Ribble Valley Borough Council
Housing & Development Control

Application no: **3/2021/1066**

Address: **3 Portfield Bar Whalley BB7 9DL**

Proposal: **Proposed first floor bedroom extension to rear of the property.
Resubmission of 3/2020/1001.**

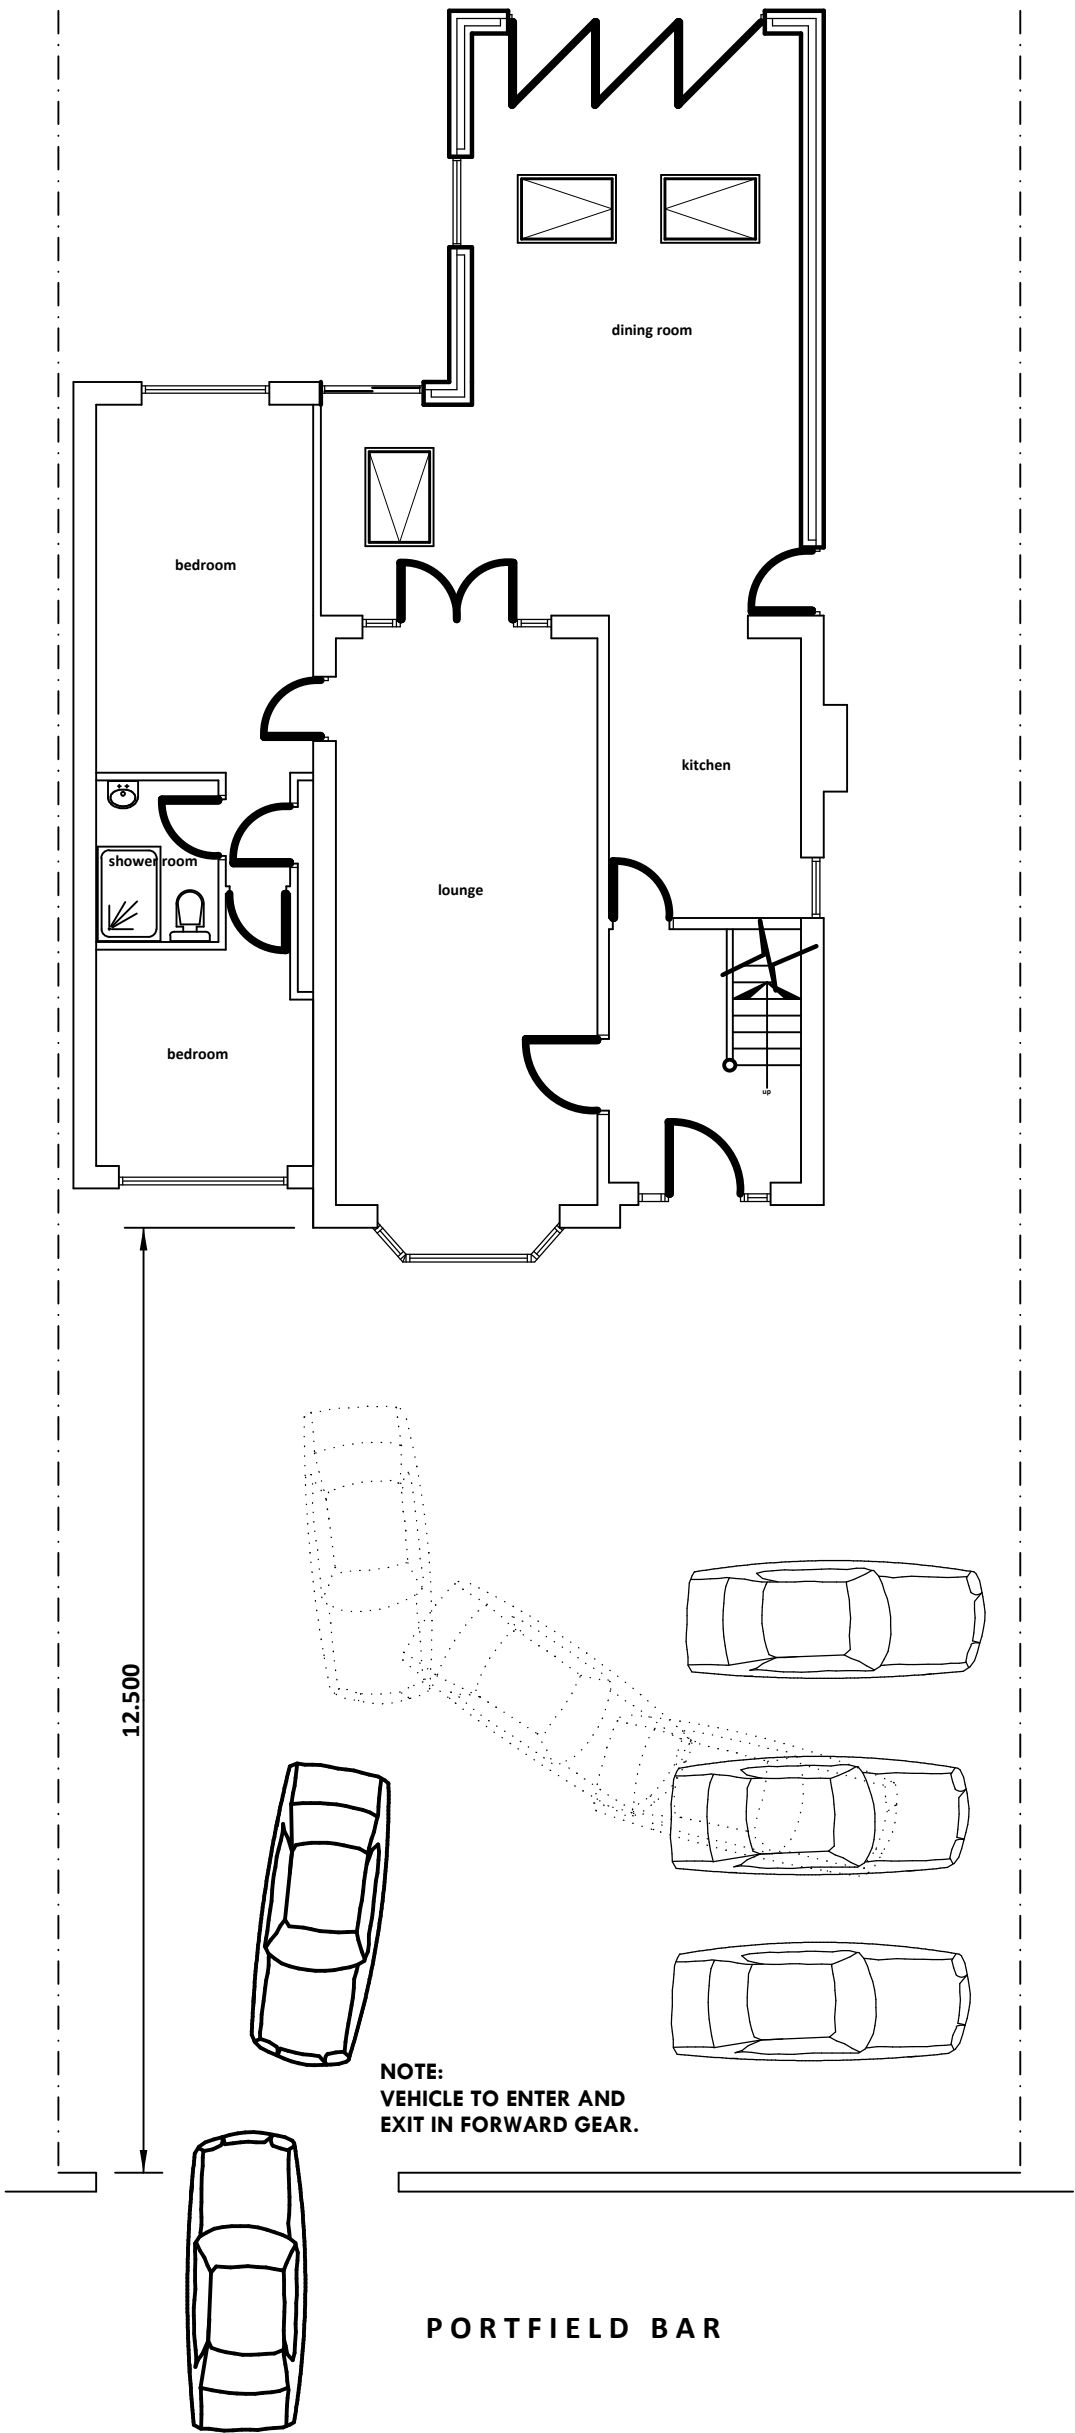
The LHA have reviewed Khalid Khan drawing number 085/11/20/3/02@A3p titled "Car Parking Layout" and are satisfied that the access arrangements complies with the LHAs guidance and so the LHA have no further comments to make.

The LHA have reviewed Khalid Khan drawing number 085/11/20/3/02@A3p titled "Car Parking Layout" and are satisfied that the parking arrangements complies with the LHAs guidance. Therefore, the LHA have no objection to the proposal.

1. The development hereby permitted shall not be occupied until such time as the parking and turning facilities have been implemented in accordance with Khalid Khan drawing number 085/11/20/3/02@A3p. Thereafter the onsite parking provision shall be so maintained in perpetuity.
